Our Reference: SYD11/00194/05 (A13489423)
DP&E Ref: SSD 5093 MOD 2

SECTION 96(1A) MODIFICATION TO NORTH RYDE STATION PRECINCT – M2 SITE AT DELHI ROAD, RYDE

Reference is made to the Department of Planning and Environment (DP&E) email dated 26 May 2016, regarding the abovementioned application which was referred to Roads and Maritime Services (Roads and Maritime) for comment.

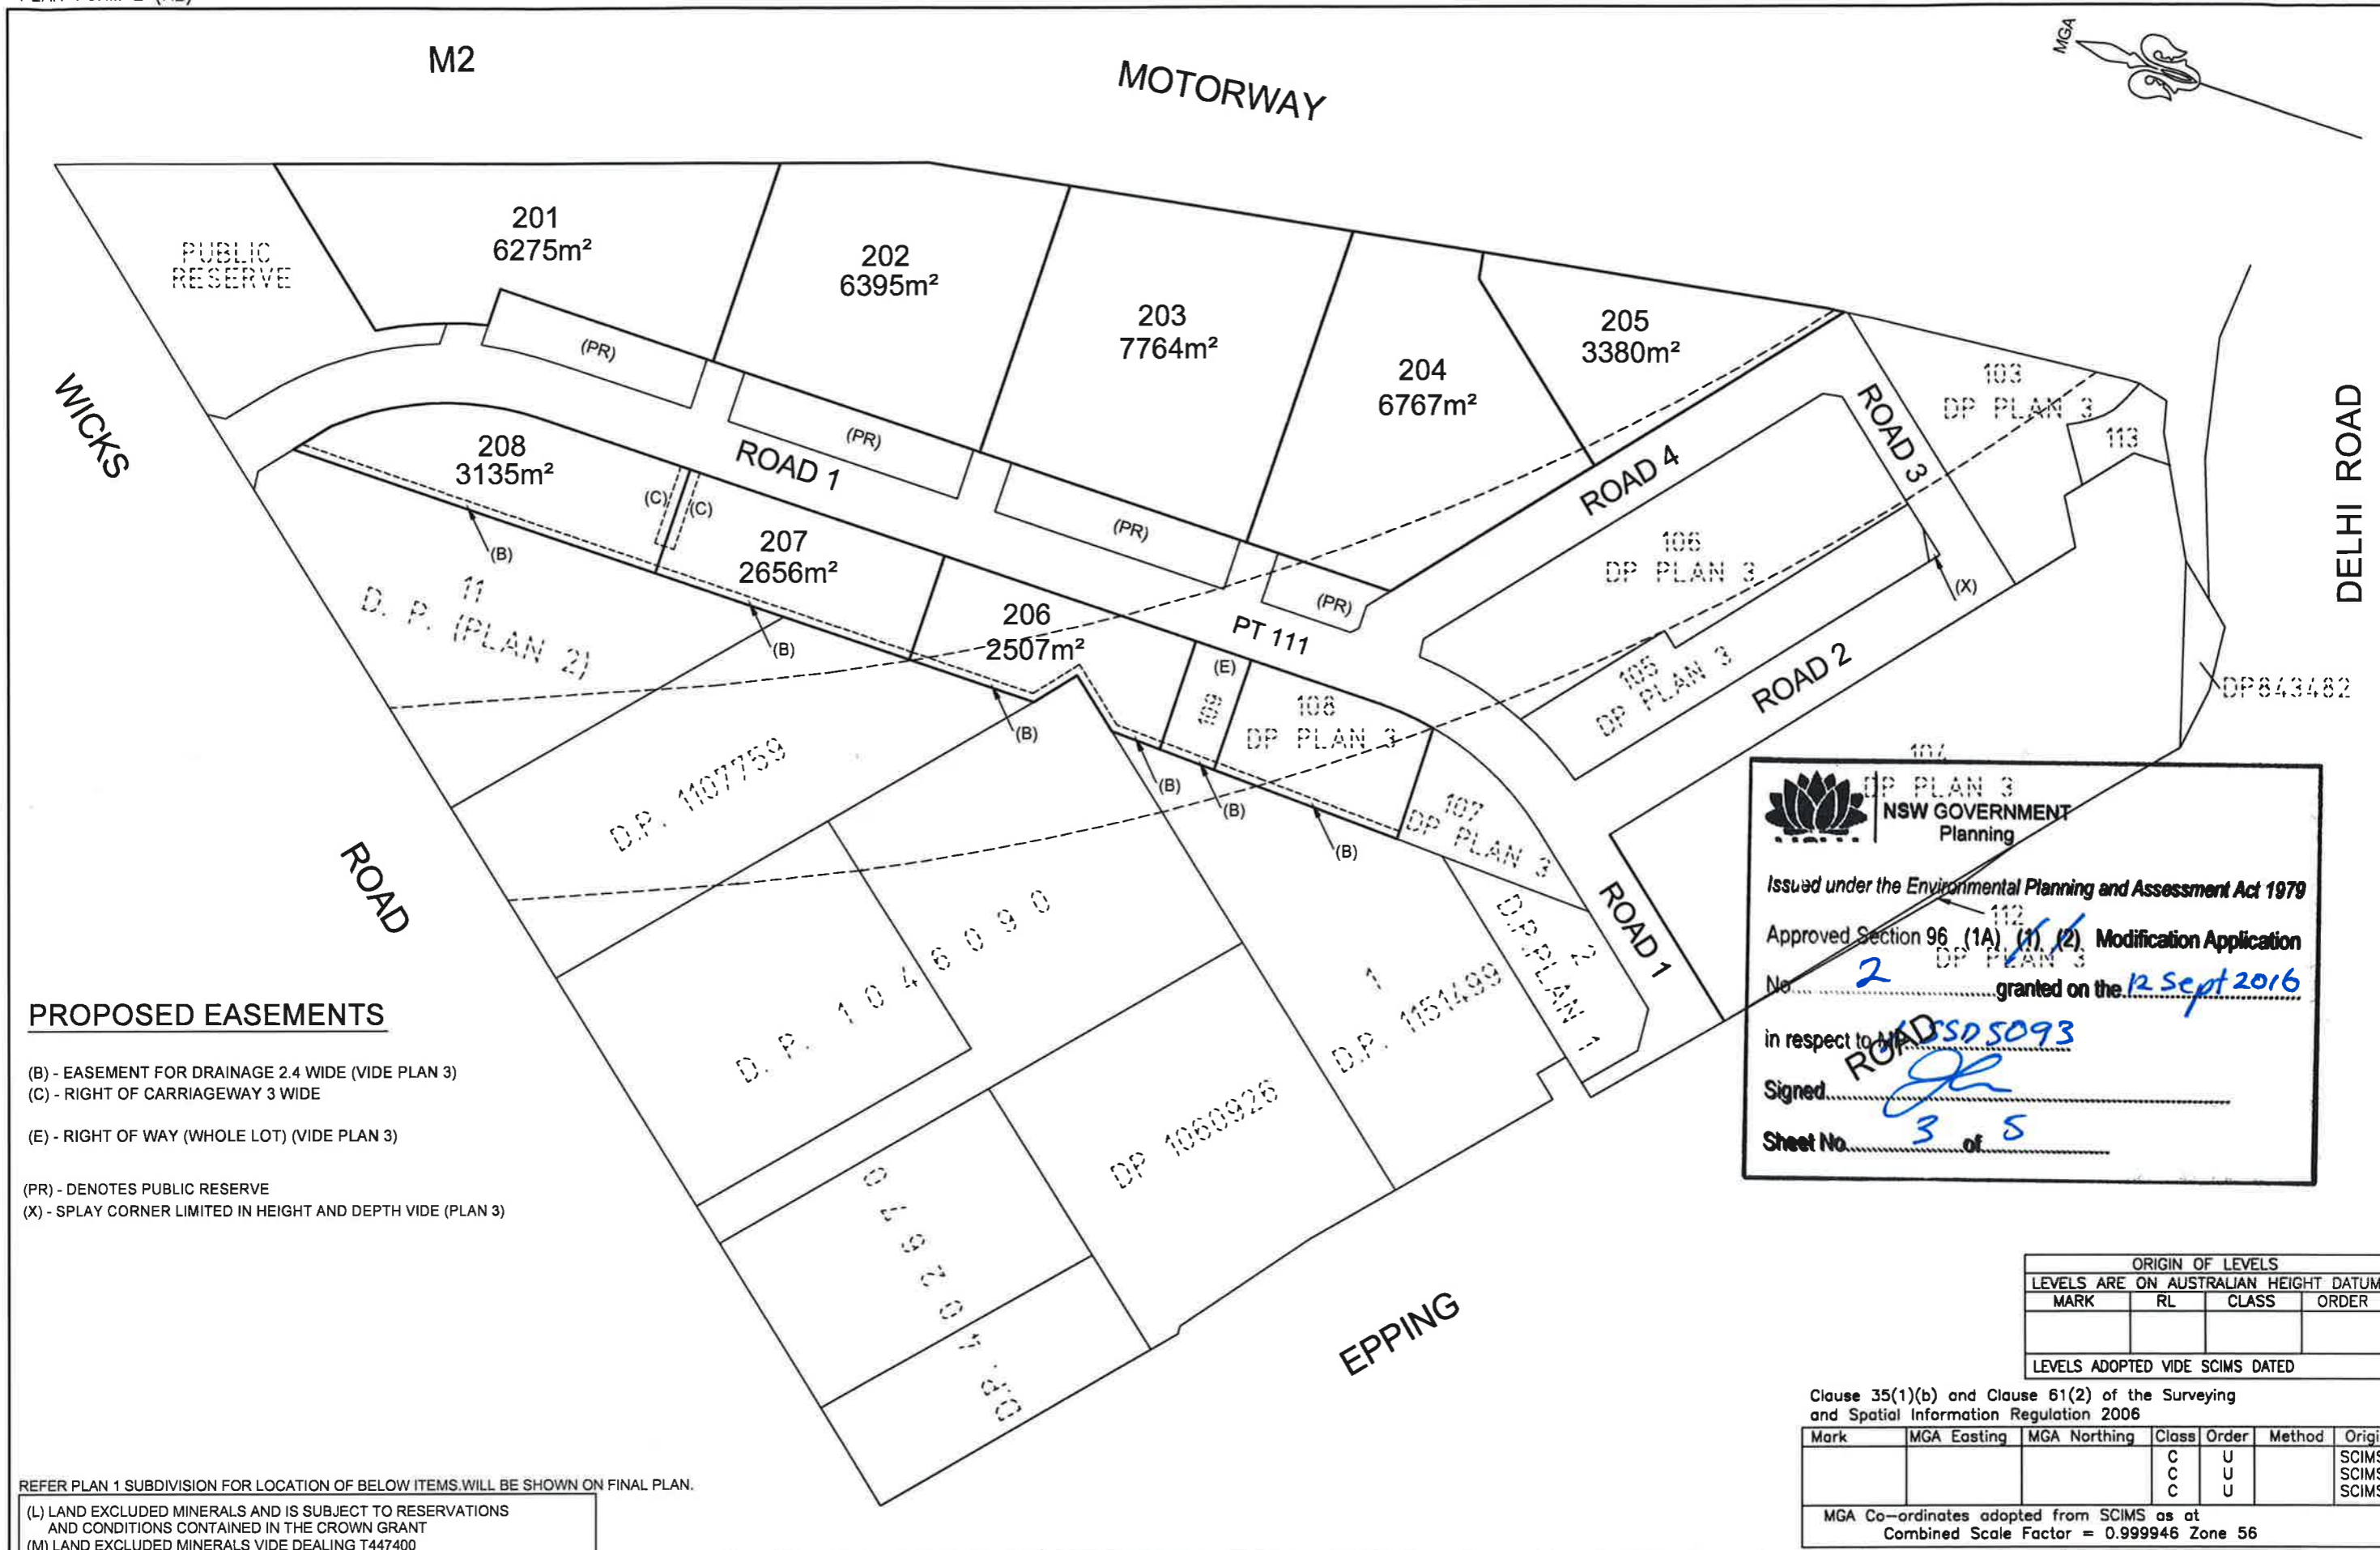
4. In reference to the amendment no.3 of the proposed modifications, the land on which the bridge is located is to be dedicated as public road. In this regard, the amendment should be read as:

"Updated subdivision plans to allow for dedication of the pedestrian bridge landing pad as public road"
